## Examining Authority's Second Written Questions

Responses to the Examining Authority's (ExA) second written questions should be received by the ExA on or before **Wednesday 4 March 2015**. The questions are principally addressed to the parties stated. However, the ExA invites all interested parties to consider whether they have evidence on the issues raised and to provide answers to any questions where they can. The questions are not set out according to any order of importance or hierarchy.

Figure 11.16

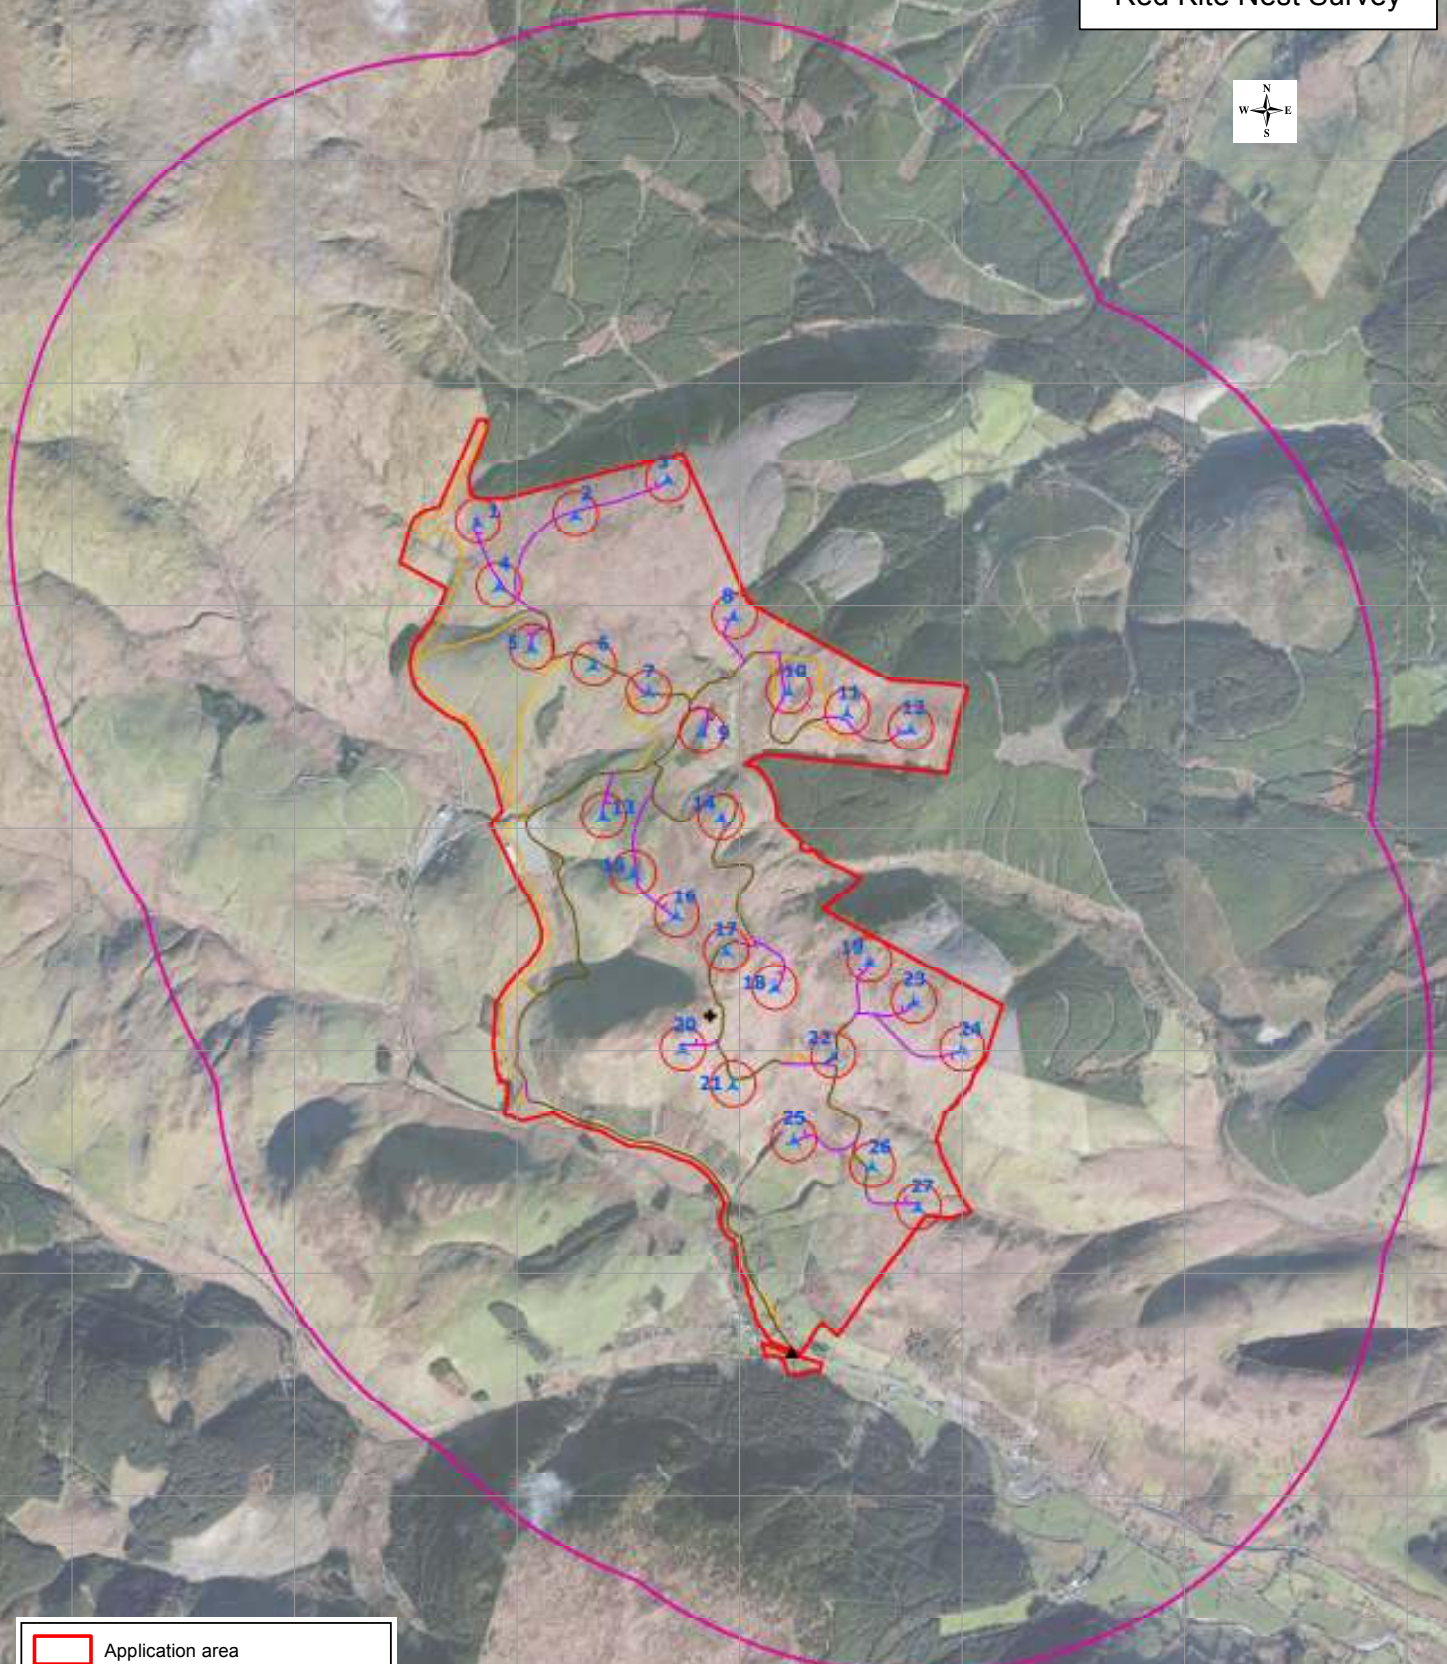
4.17	<b>Applicant</b>	<p>Paragraph 5.23 of the applicant's comments submitted for Deadline III, refer to a Red Kite nest survey that was undertaken between March and July 2014. Please could the applicant provide a copy of the survey report, and state whether or how these findings affect the impact assessments in the ES Ecology chapter and the HRA? In the event that they do, an updated impact assessment will need to be provided.</p>
